From: Paul Cann
Sent: 24 January 2018 12:24
To: Planning.Responses
Subject: RE: Planning Consultation on: A/219/17/PL

Engineers comments in respect to surface water drainage:

APPLICATION **A/219/17/PL**

Site Address: Land East of Windy Ridge Mayflower Way Angmering BN16
4AY

Job: e17134 Dwg No: 002 Rev: - A1

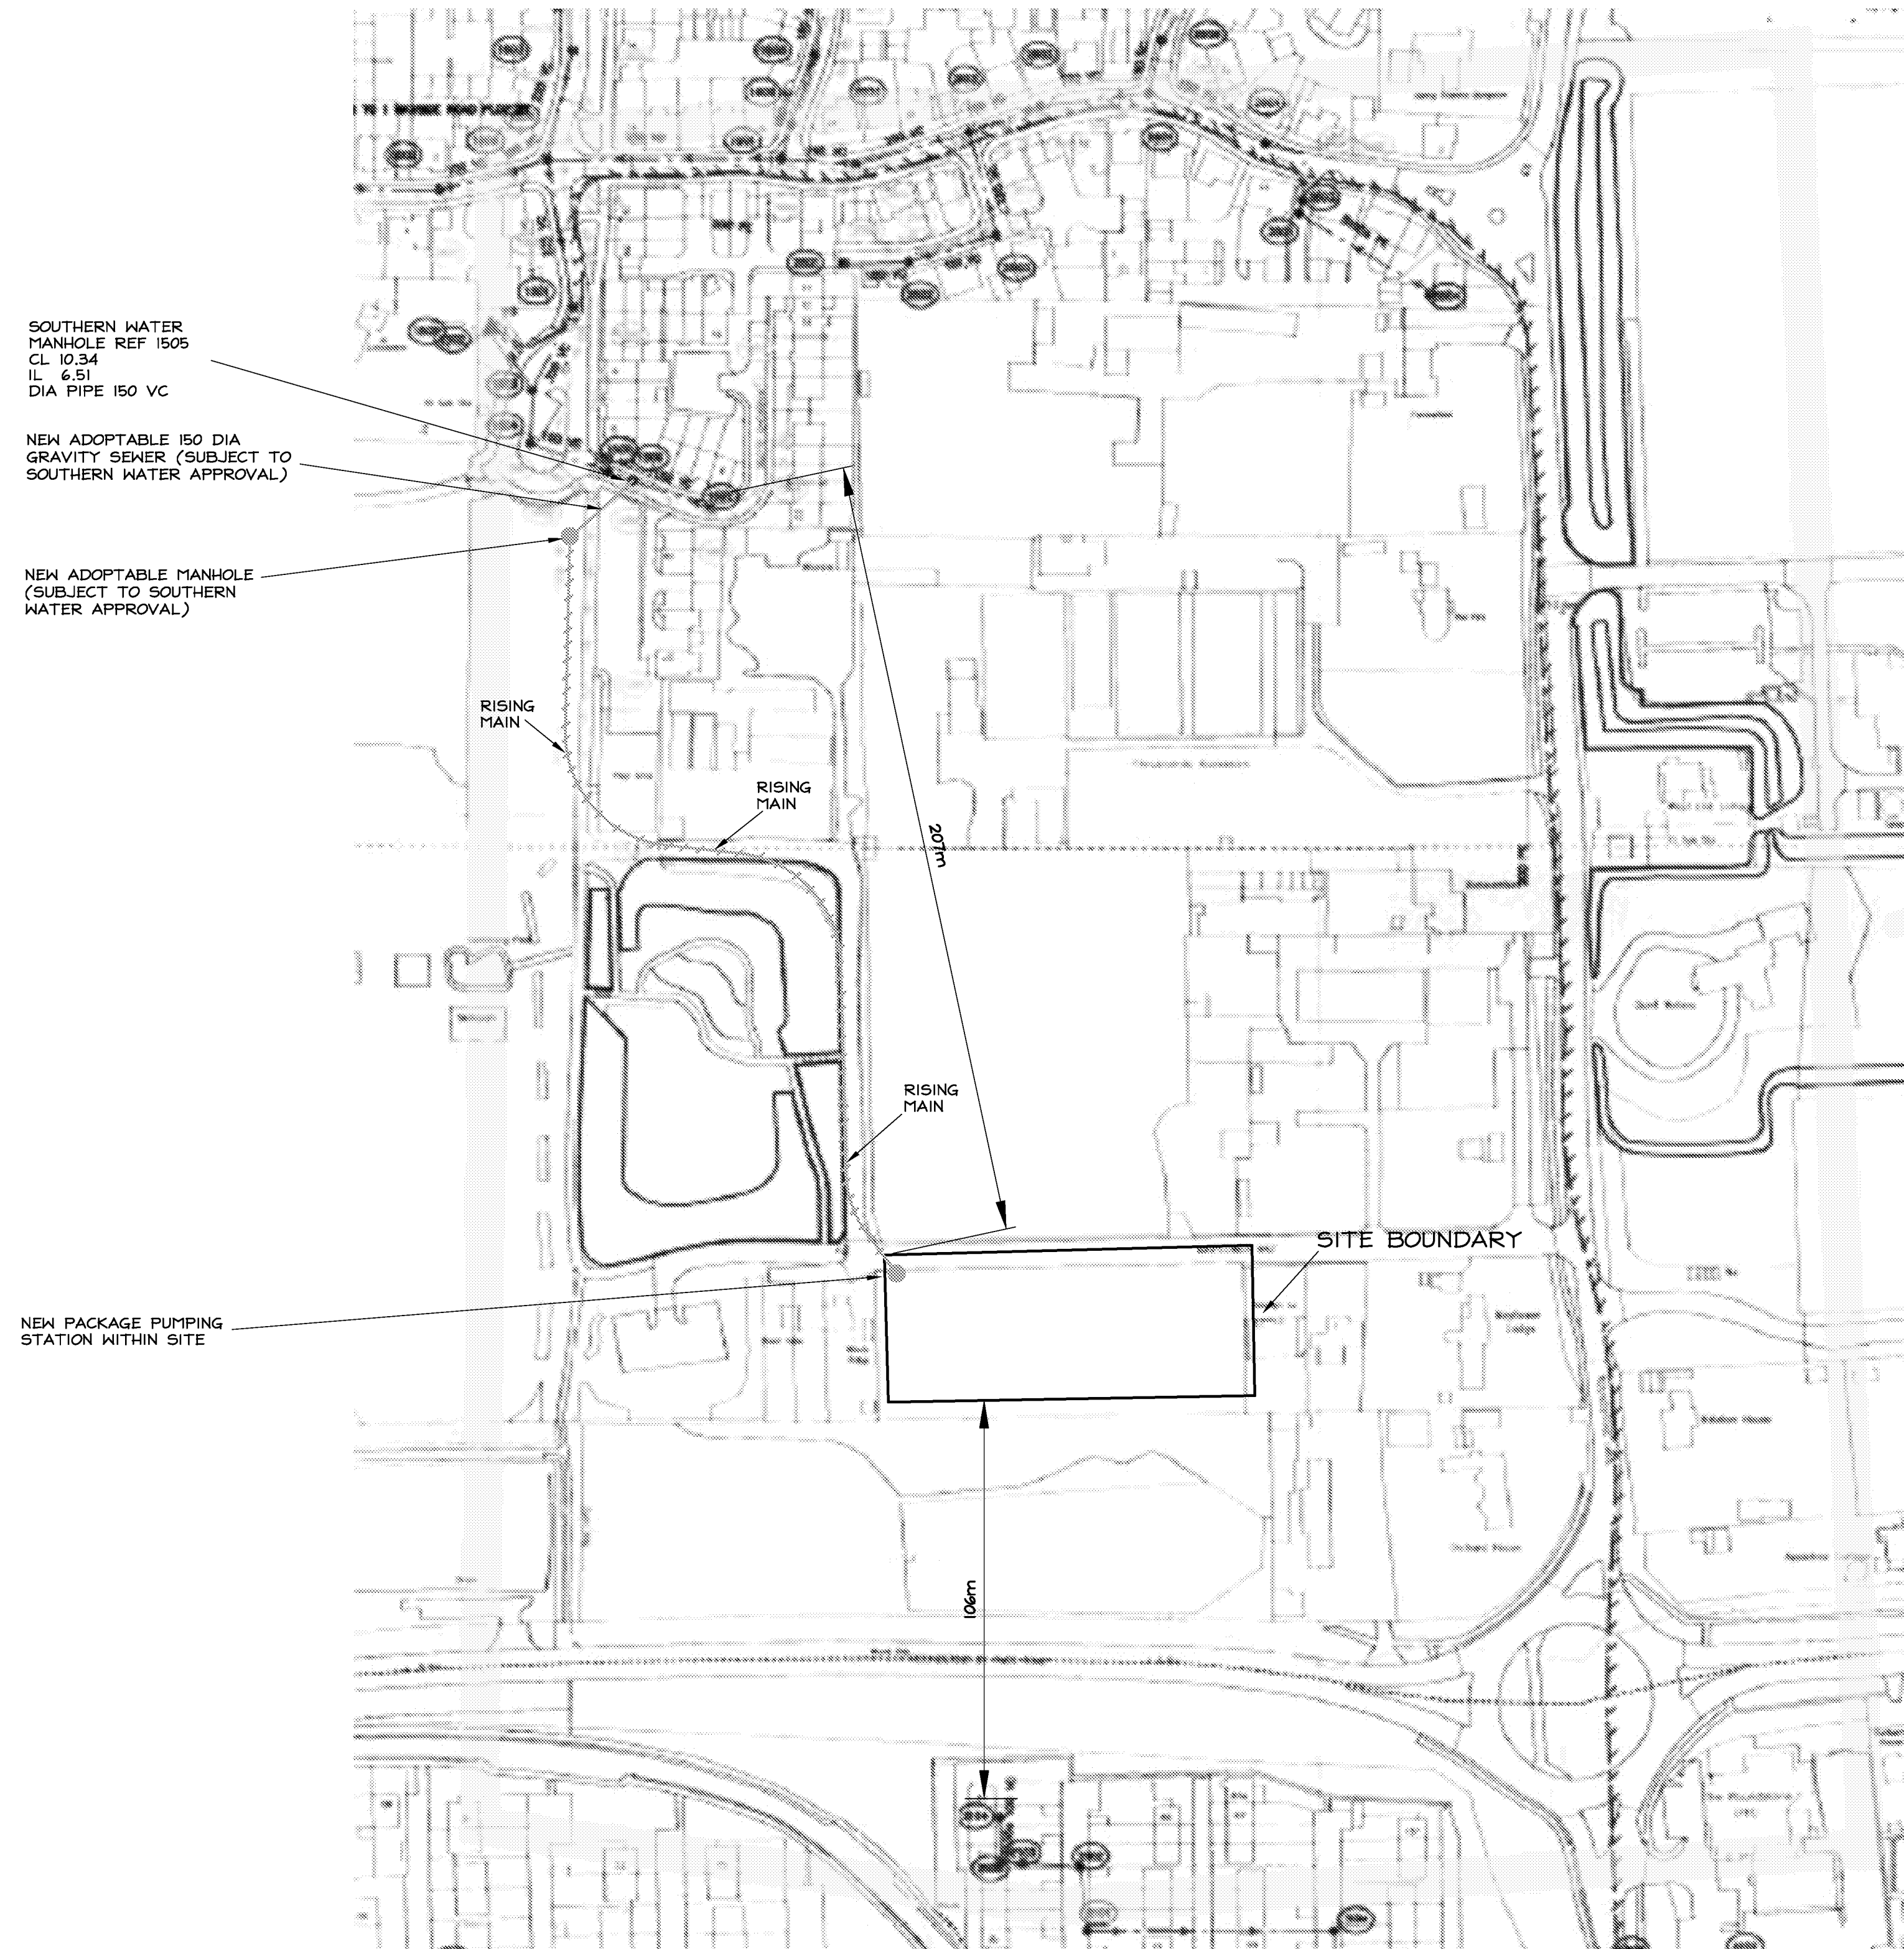
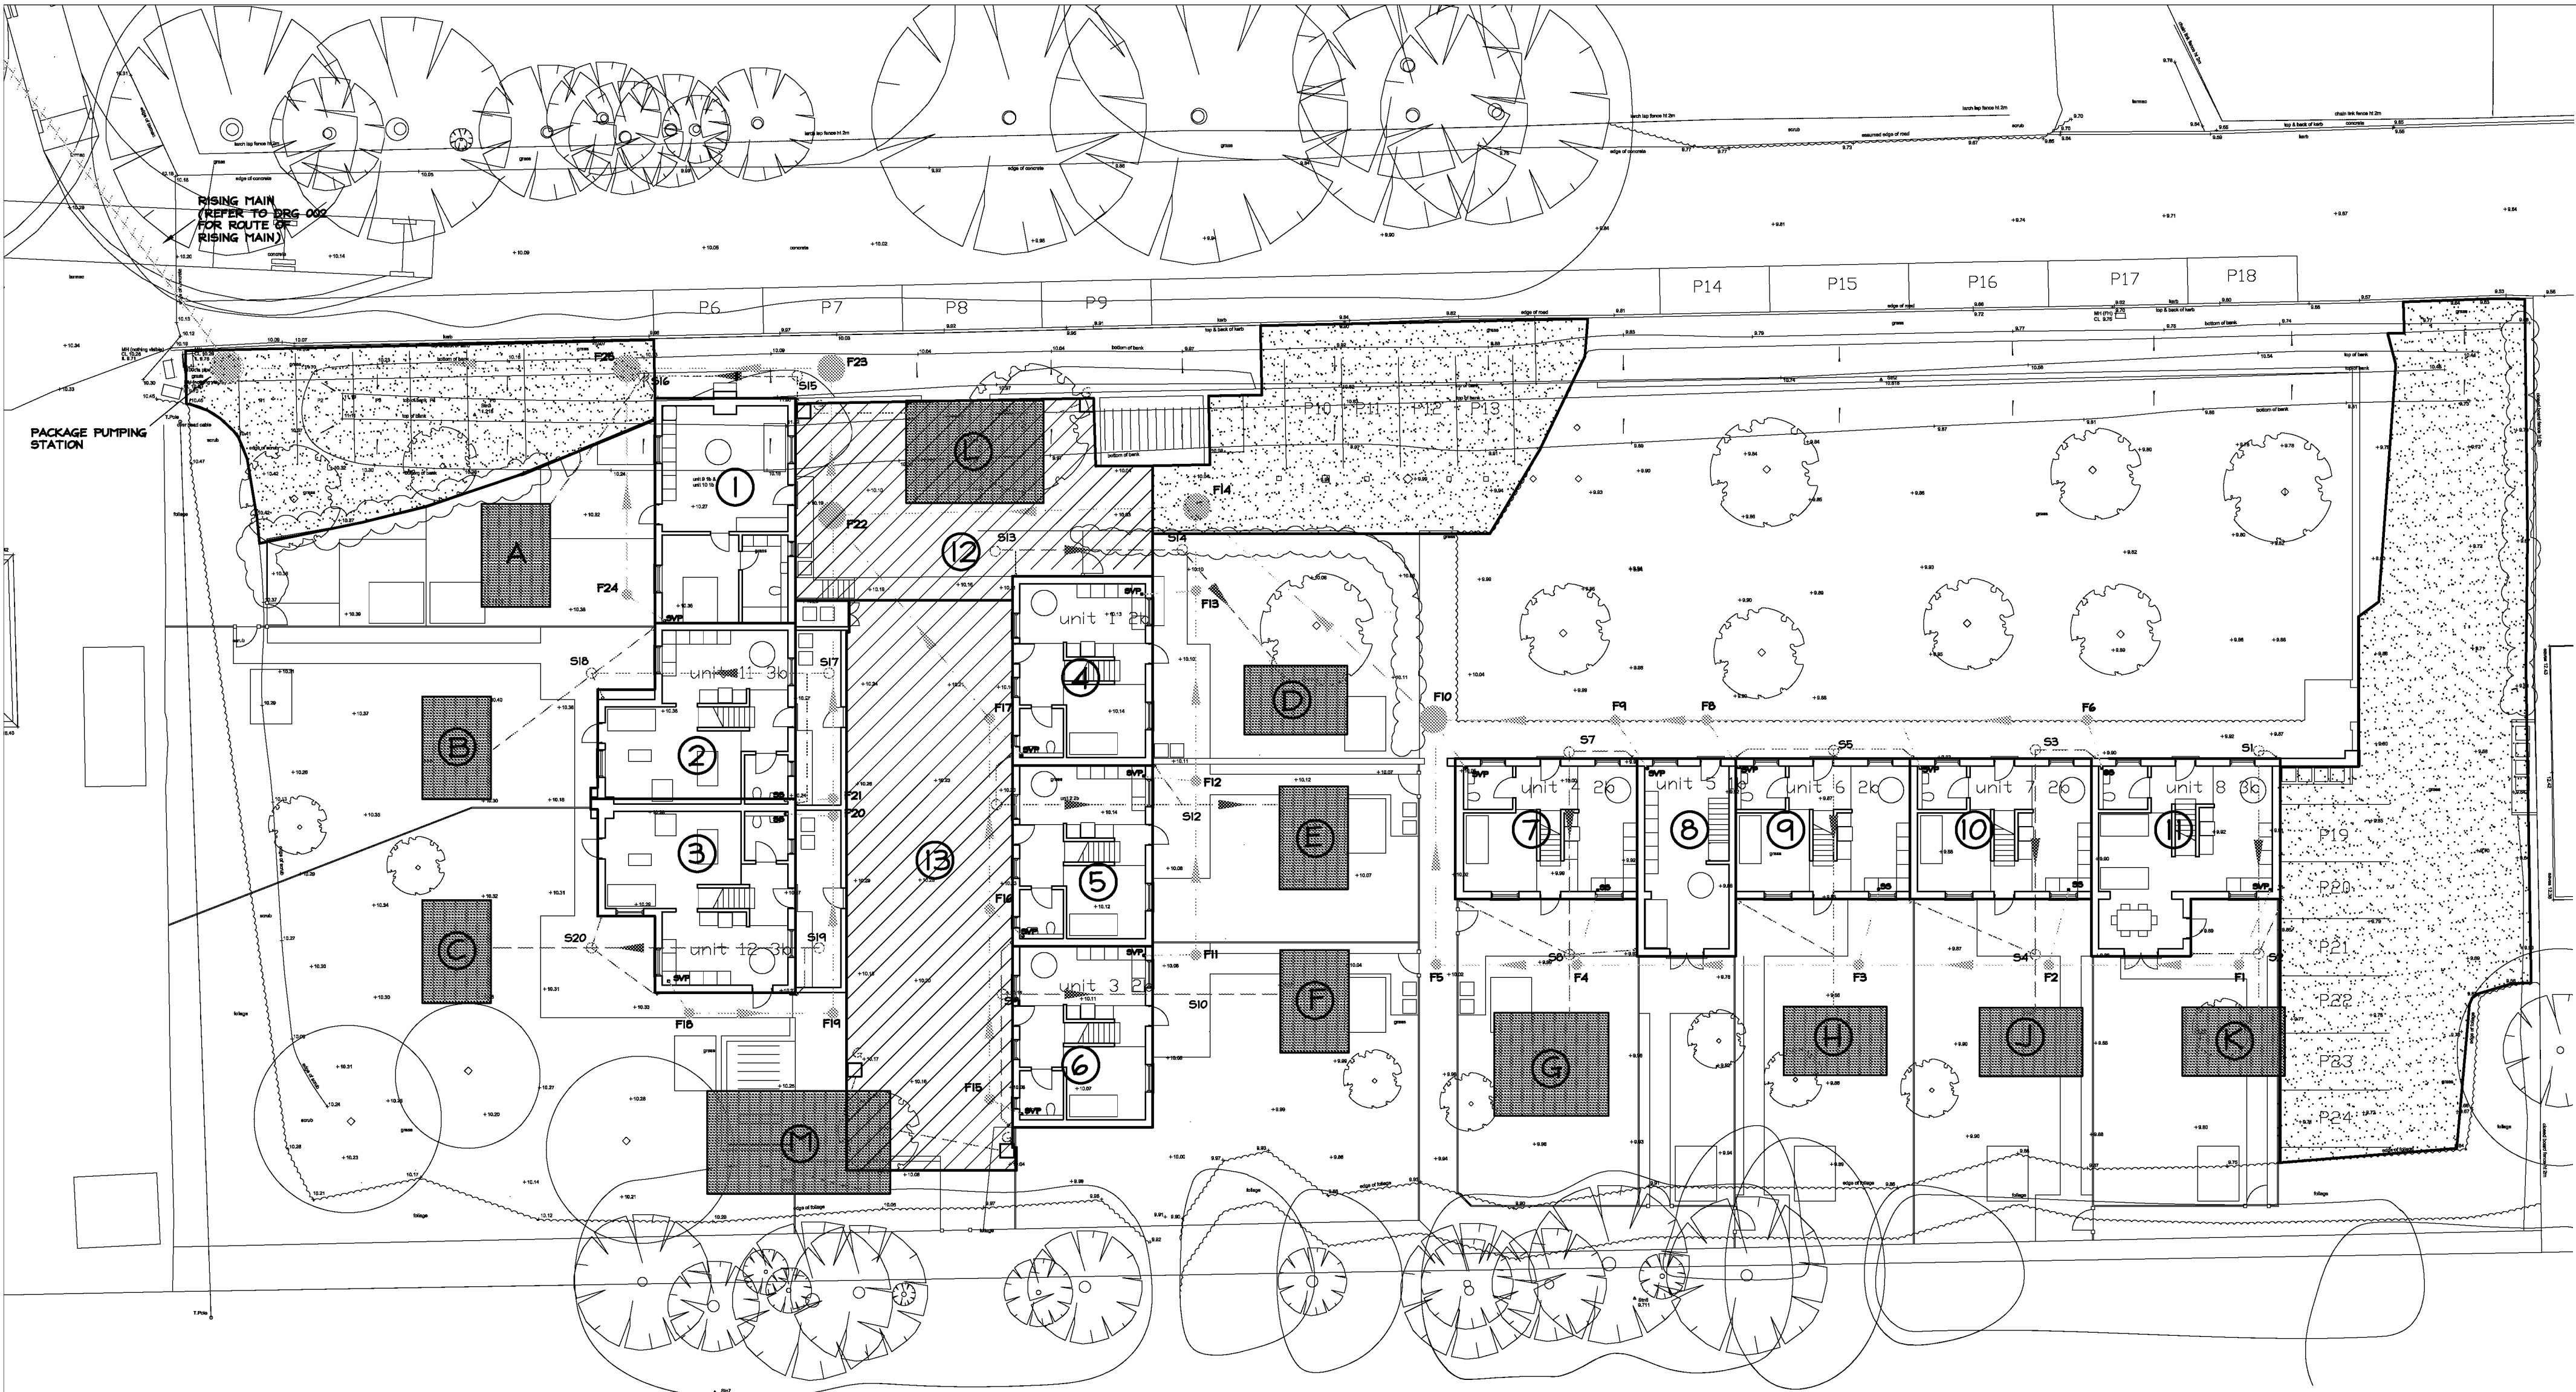
The proposed use of soakaways is acceptable in principle, following the further winter percolation testing. Groundwater levels in this area are not expected to be very high, however, the proposal to keep structures as shallow as possible is wise, in order to ensure seasonal fluctuations in groundwater levels do not compromise the design.

The applicant should note that 40% allowance for climate change should be used in the design (as per our enclosed guidance notes), rather than 30%.
